From: Ian Stocks [REDACTED] **On Behalf Of** FRS Water and Access
Sent: 22 February 2022 16:01
To: Planning.Responses <Planning.Responses@arun.gov.uk>
Subject: Planning consultation - WA/5/22/PL Morelands Arundel Road Fontwell BN18 0SB

Having viewed the plans for planning application WA/5/22/PL, for the demolition of 1 No dwelling & erection of 5 No dwellings with associated car parking and access. This site is in CIL Zone 2 and is CIL Liable as new dwellings, the access route to the proposed site does not appear to be suitable for a fire appliance to gain access.

Drawing Number	11636/2200	Rev.	P5
----------------	------------	------	----

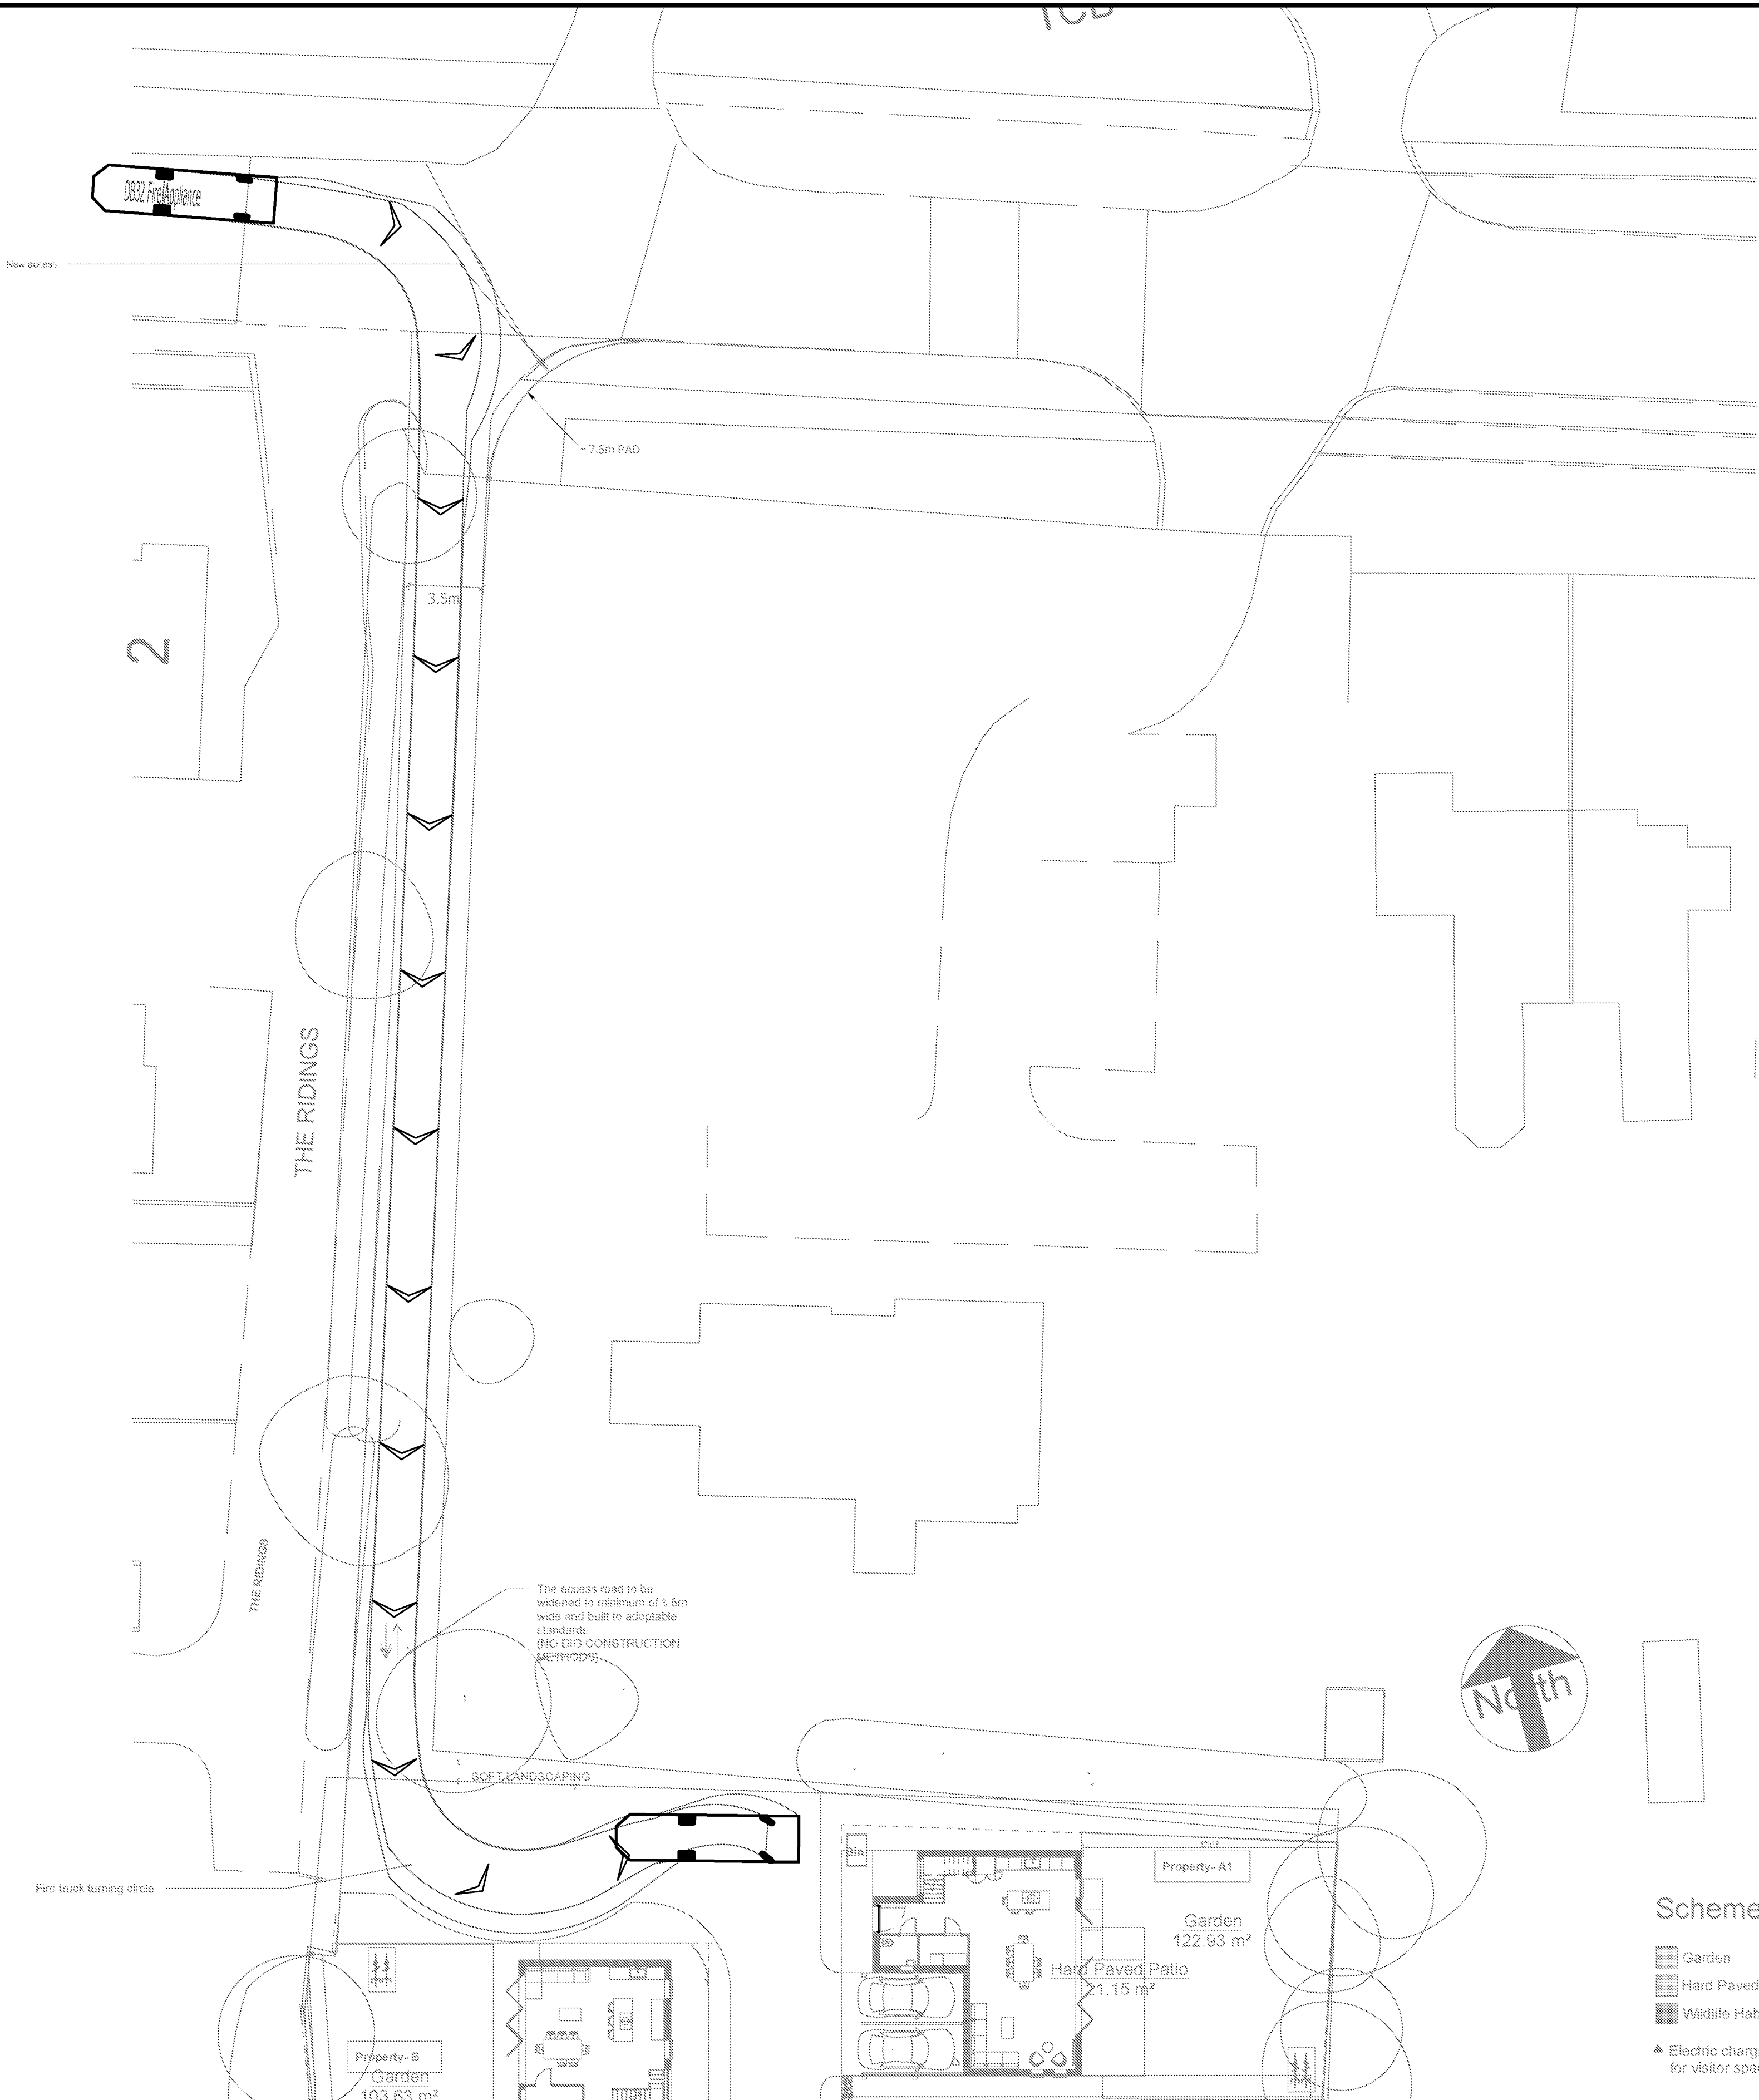
In accordance with the requirements of Approved Document – B (AD-B) Volume 1 2019 edition: B5 section 13, vehicle access for a pump appliance should be provided to within 45 metres of every point within each dwelling, any area not within this distance will need to be mitigated by the installation of domestic sprinkler or water mist system to BS9251 or BS8458 standard. The new build property is 110 metres from the main road so access to these dwellings is key.

Evidence is also required to show sufficient turning facility is provided for a fire appliance to turn and make their exit, a requirement of AD-B Vol 1 B5 section 13.
